CLEVE HILL SOLAR PARK

THE APPLICANT'S RESPONSES TO SUBMISSIONS RECEIVED AT DEADLINE 4

Appendix 2 - Email Correspondence from Network Rail

From: Maniraj Sunil [REDACTED] on behalf of Abnormal Loads Enquiries
<AbnormalLoadsEnquiries@networkrail.co.uk>
Sent: 21 June 2019 12:34
To: Andy Pearce
Subject: RE: AIL Access to Cleve Hill Substation - Network Rail
Attachments: 19-964.TC01 Cleve Hill transport configuration R0.pdf; 0021 - 07.03.19. AIL Access Study - Cleve Hill Solar Park Substation.pdf

Graveney Railway Bridge

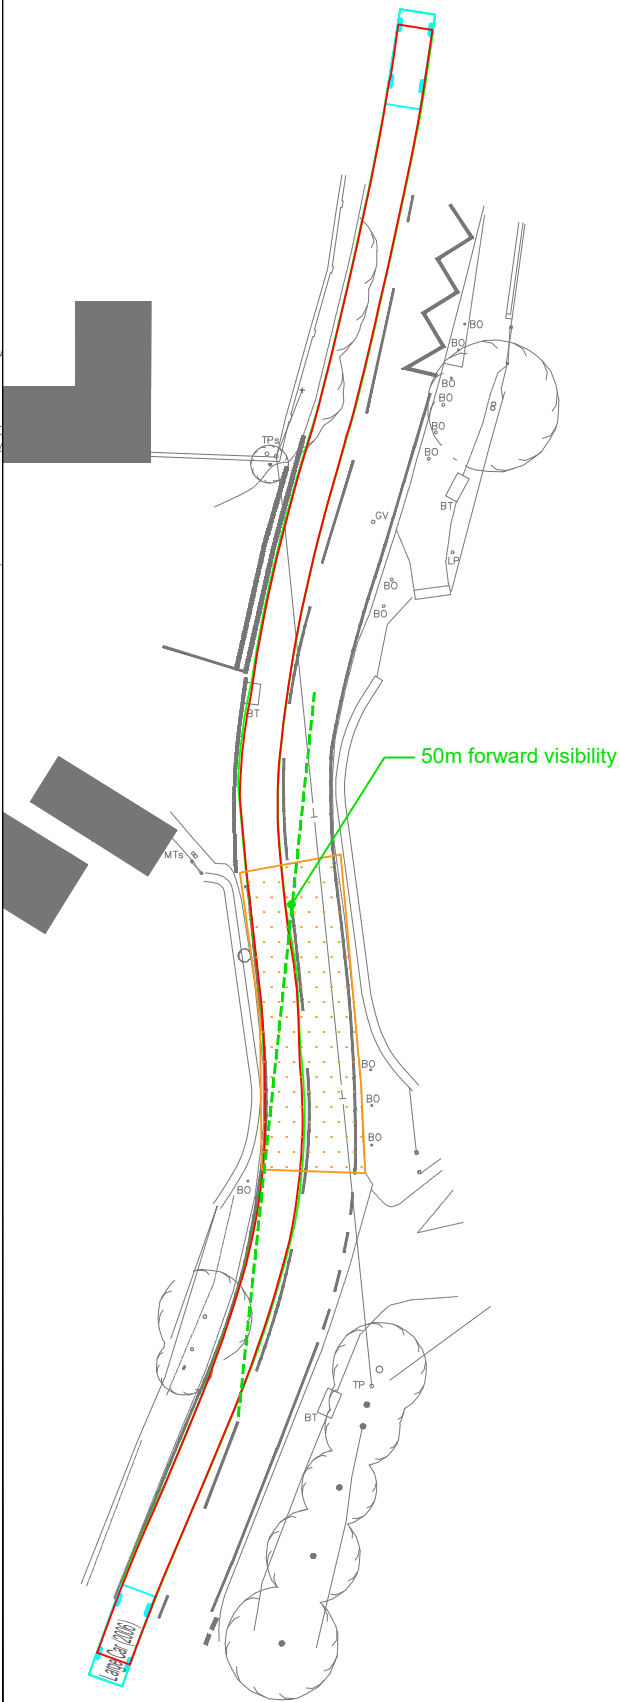
The proposed AILs are accepted to cross VIR 761 Graveney Bridge with following conditions.

- Number of movement over the bridge is limited to 4 times as detailed in the initial application
- Only the submitted vehicle configurations are allowed (see attached).
- The AIL should cross the bridge under track possessions with watchers monitoring the bridge for any signs of distress.
- Please arrange the track possession and watchers when needed by contacting Asset Protection London South East (email: AssetProtectionLondonSouthEast@networkrail.co.uk)
